Recommendation Report for Planning Permission for Works or Extension to a Dwelling

REF NO: R/44/26/HH

LOCATION: 26 The Crescent
Rustington
BN16 2PE

PROPOSAL: Proposed single storey rear extension and new window to side west elevation.

REAR SOUTH ELEVATION
PROPOSED ELEVATIONS

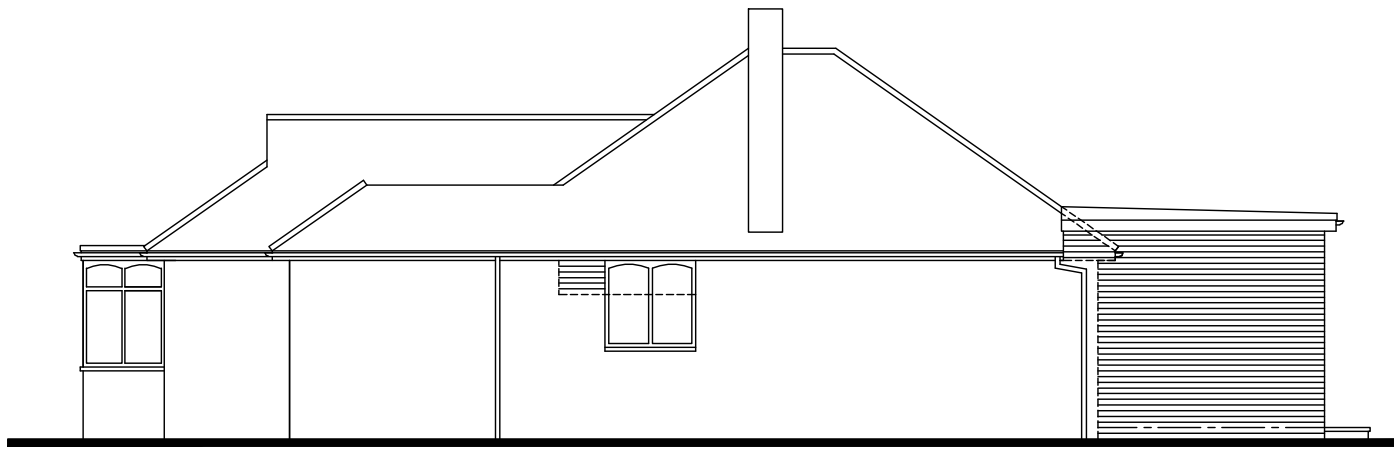
The proposed rear extension would measure approximately 3m in depth along the western side boundary and approximately 2m along the eastern side boundary. It would span the full width of the dwelling, excluding the garage, measuring approximately 6.9m, and would have a flat roof with a maximum height of approximately 3m.

The proposed fenestration would include a sliding patio door and a window on the rear (south) elevation, providing access to private amenity space. The existing doorway on the side (east) elevation would be removed and replaced with a new opening within the extension in a similar position. Additional fenestration changes include a small horizontal window on the eastern flank elevation and a new obscure-glazed window on the side (west) elevation. All windows would be white uPVC to match the existing dwelling.

A new window is proposed in the western side elevation. This would have a similar outlook to the existing opening and, due to its ground-floor position, would not introduce any additional harmful overlooking. It would also be obscure-glazed, further limiting any impact.

A small additional window is proposed on the eastern side elevation, in a similar position to an existing opening. Given the presence of other openings, its ground-floor position, and the orientation of neighbouring plots to the east, it would not result in material overlooking or loss of privacy.

PROPOSED GROUND FLOOR PLAN

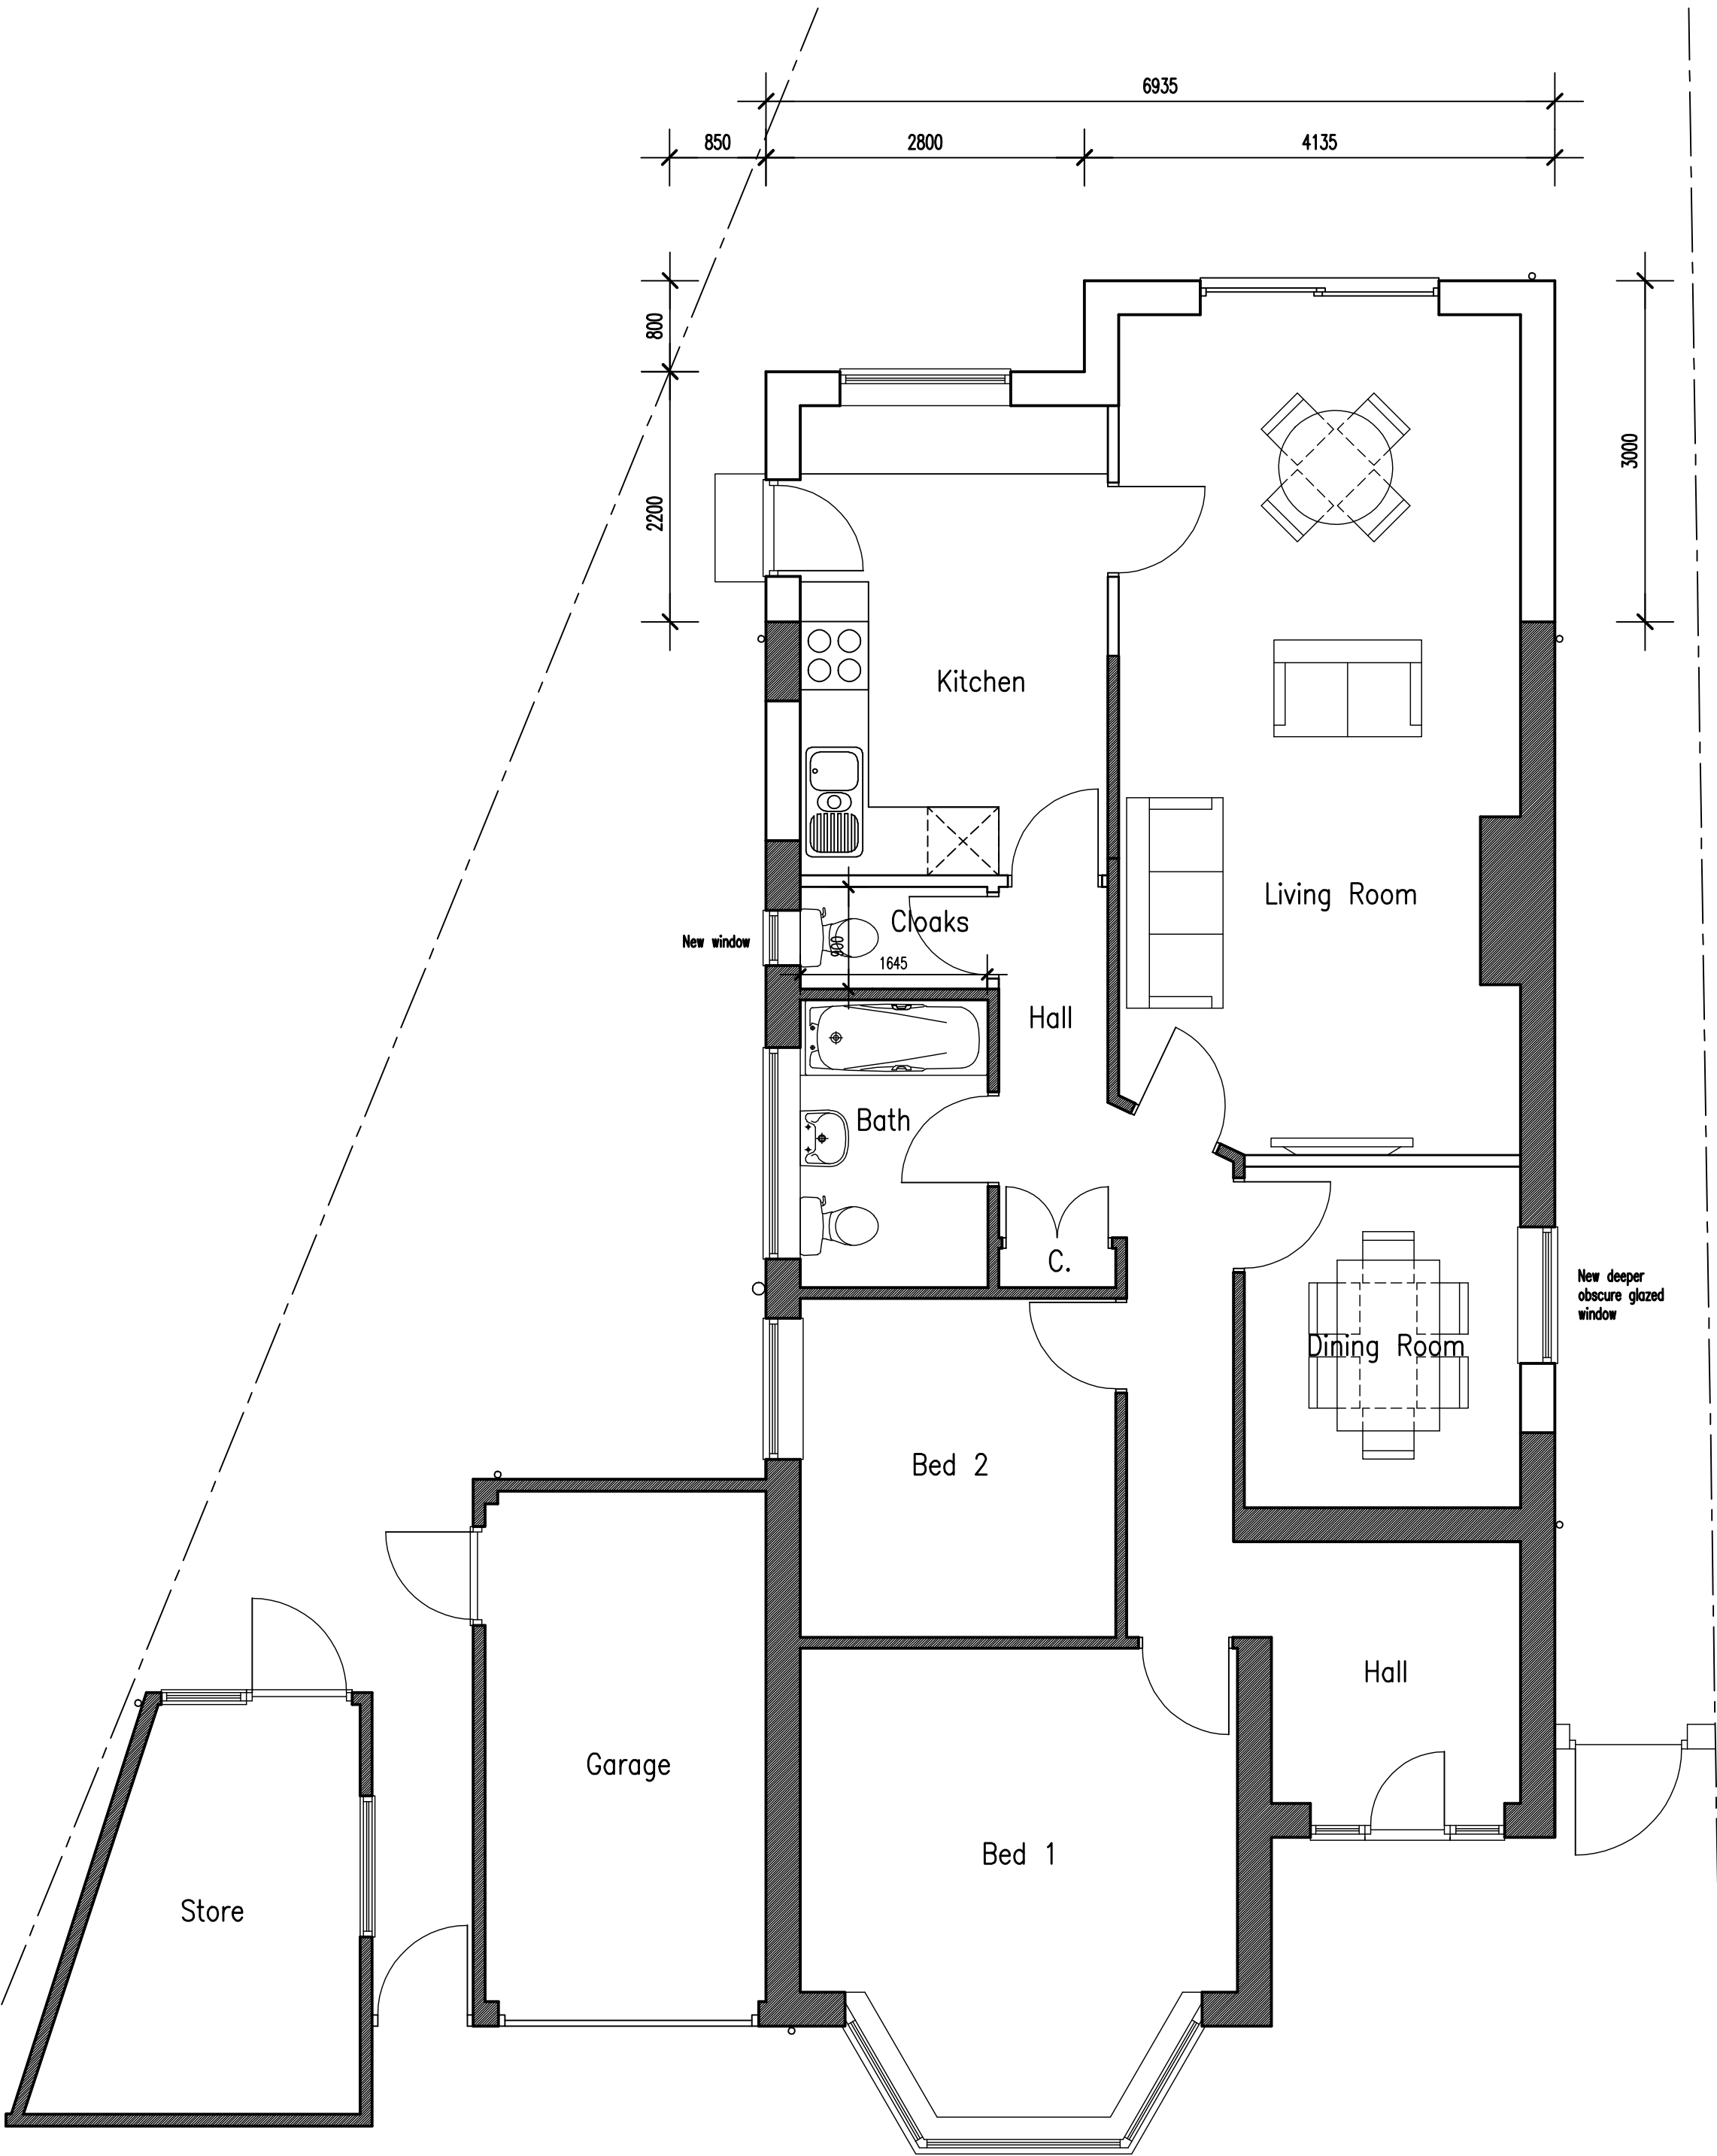
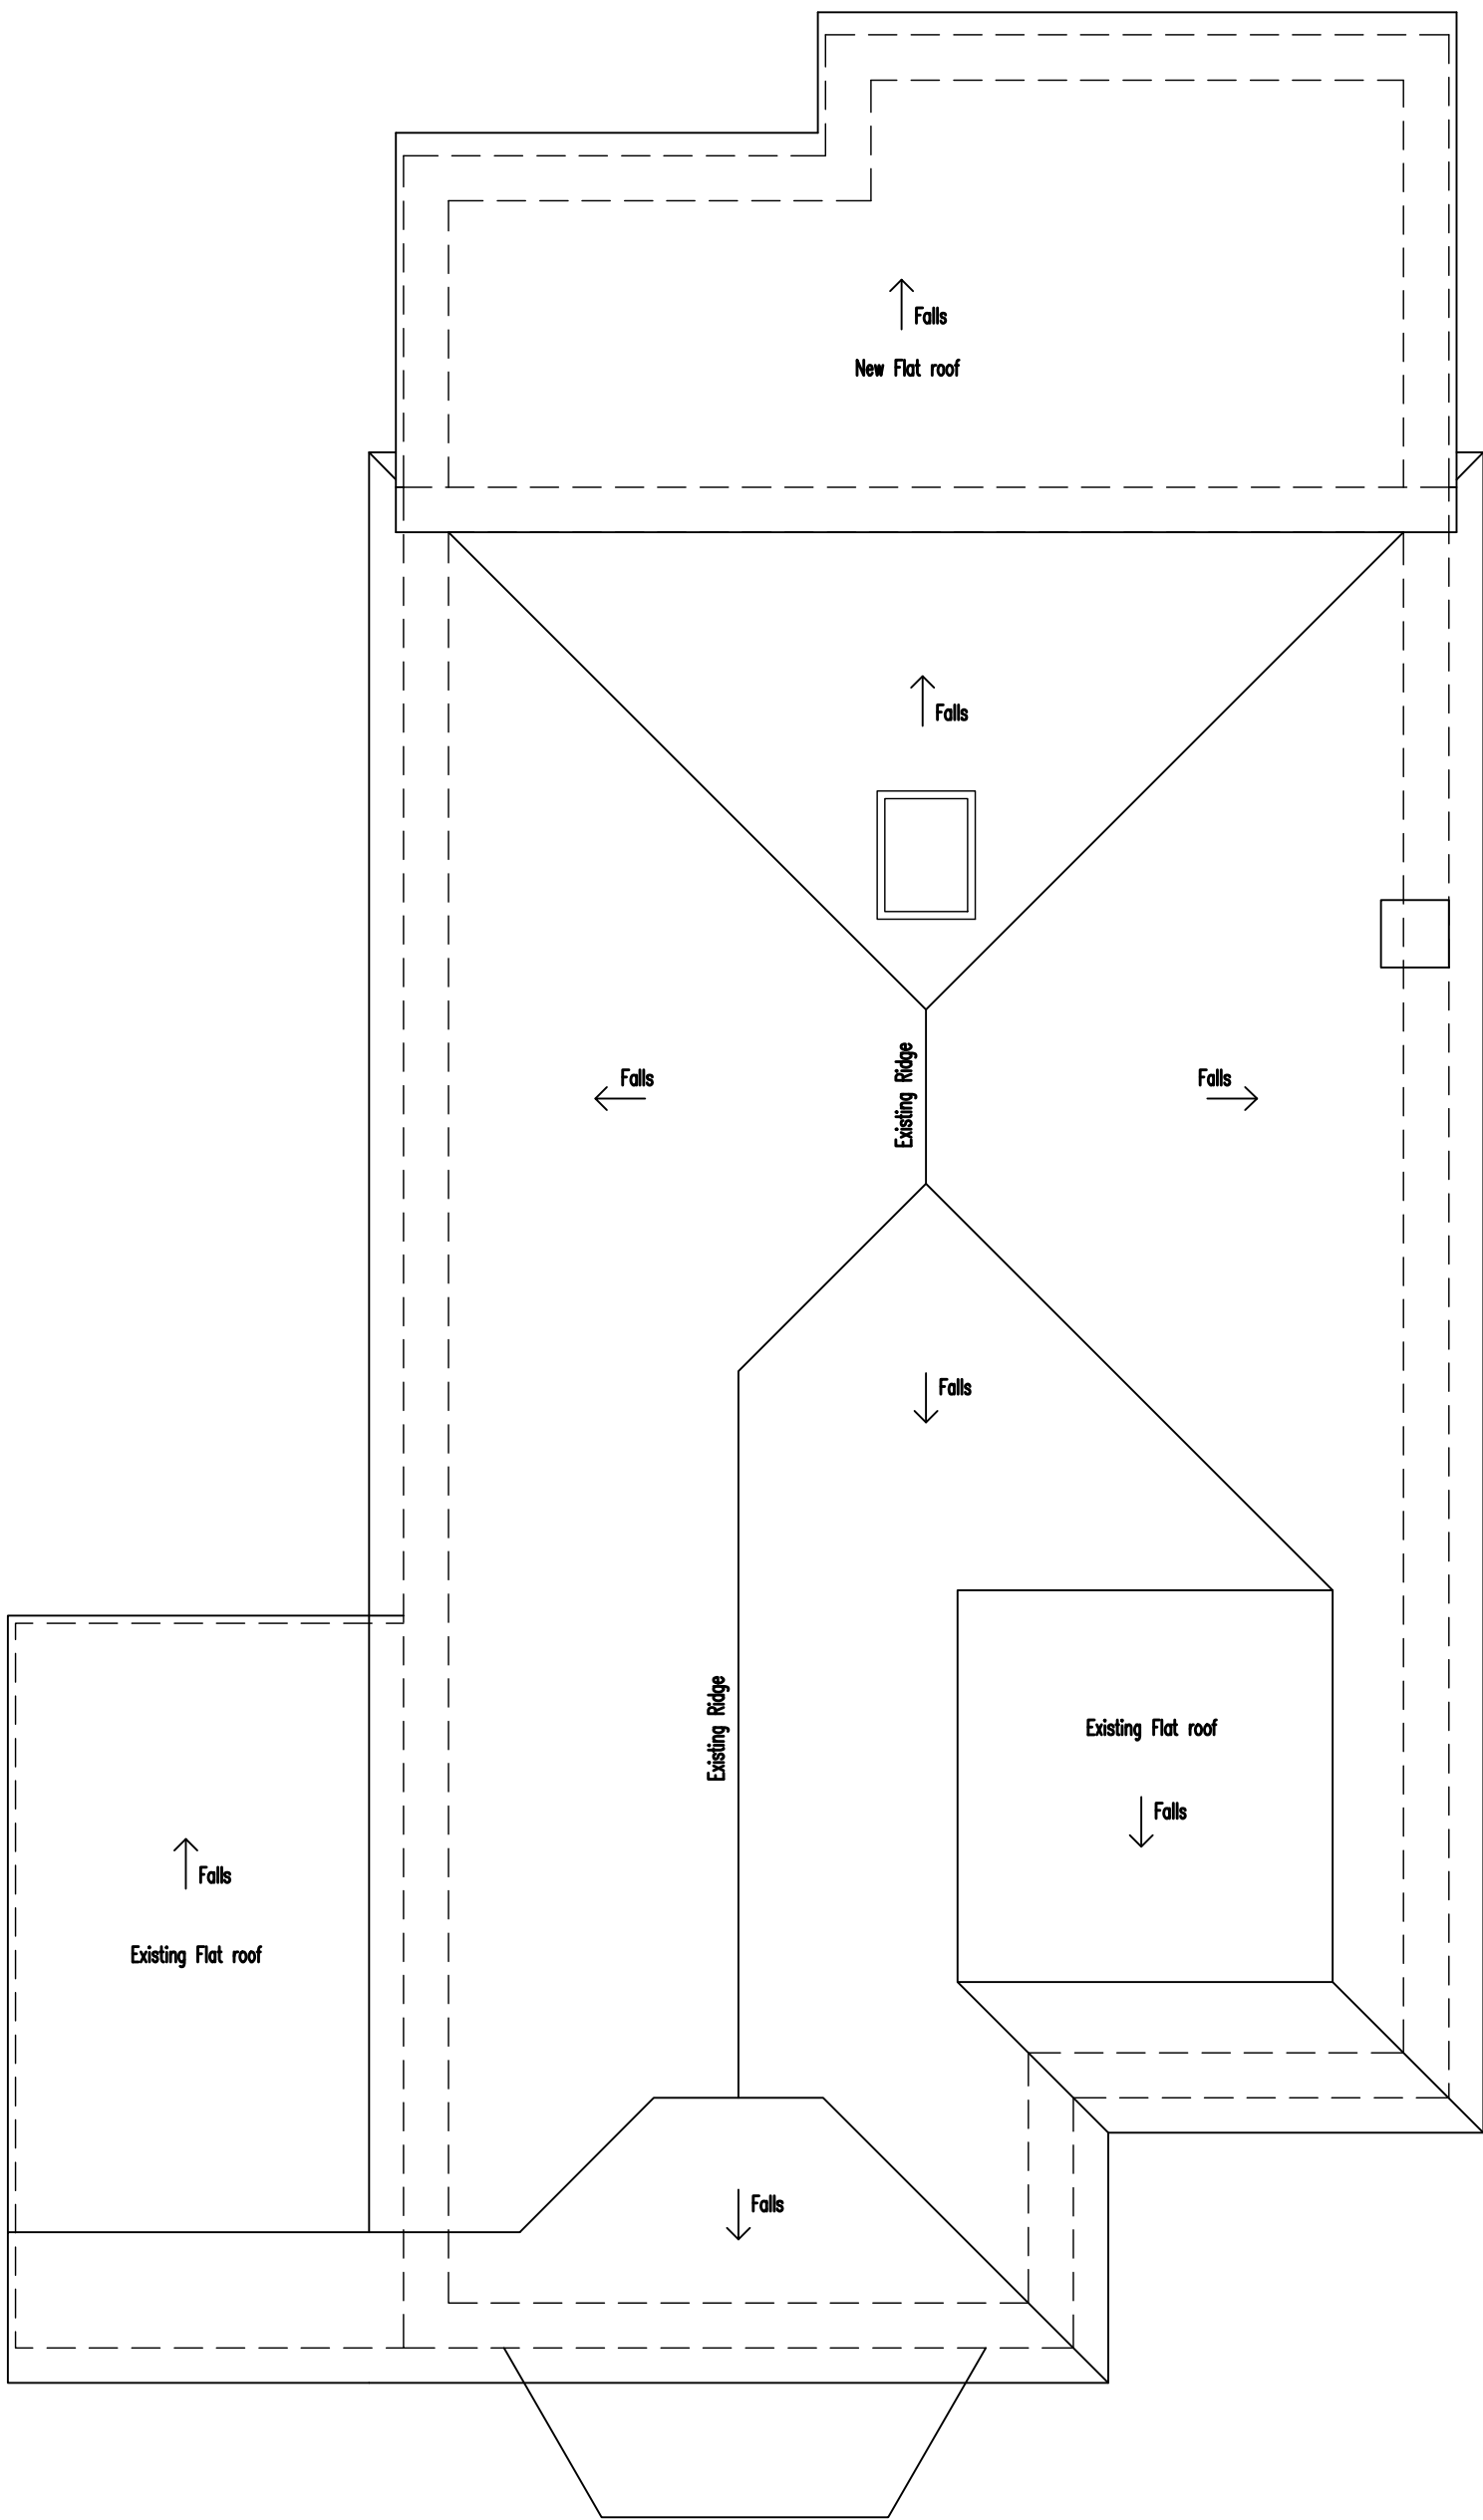
The proposed development would be set in approximately 1.2m from the western side boundary and 0.85m from the eastern side boundary.

While these separation distances would be limited, the extension would not breach the 45-degree line when measured from the nearest habitable room windows of neighbouring properties. The extension would also not exceed a depth of 3.3m, in accordance with the ADG. Given its flat roof design and modest height, the proposed extension would not result in harmful overshadowing or overbearing impacts.
